Rampion 2 Wind Farm

Environmental Statement

Volume 4, Appendix 15.1: Sea scape, Landscape and Visual Im pact Assessment consultation responses

Document Reference: 6.4.15.1

Figure 15.73d
 Viewpoint A: East Wittering

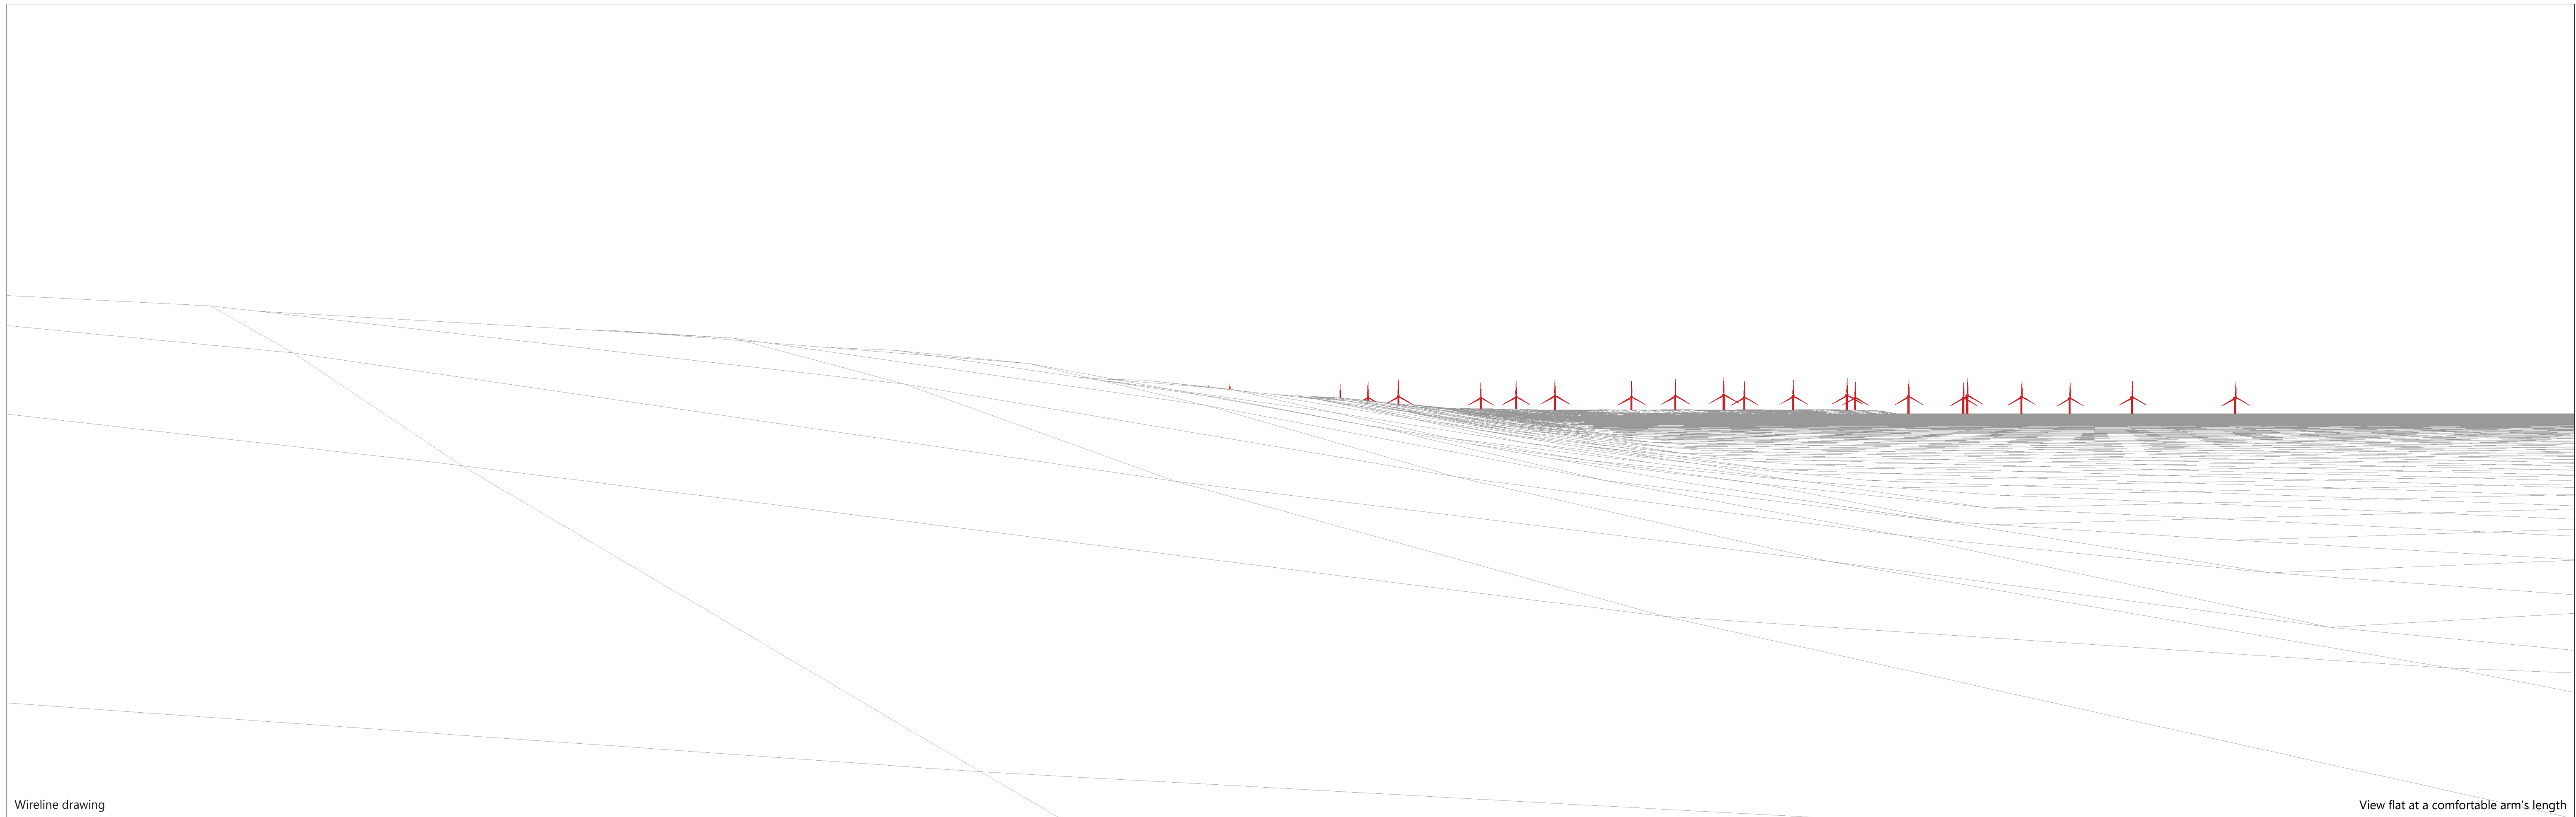
Natural England	Scoping Opinion	In addition to the viewpoints listed Natural England request that the following locations are also used as viewpoints within the SLVIA. To avoid confusion these been identified by letter rather than number.	Viewpoints selected for the SLVIA are presented in Chapter 15: Seascape, landscape and
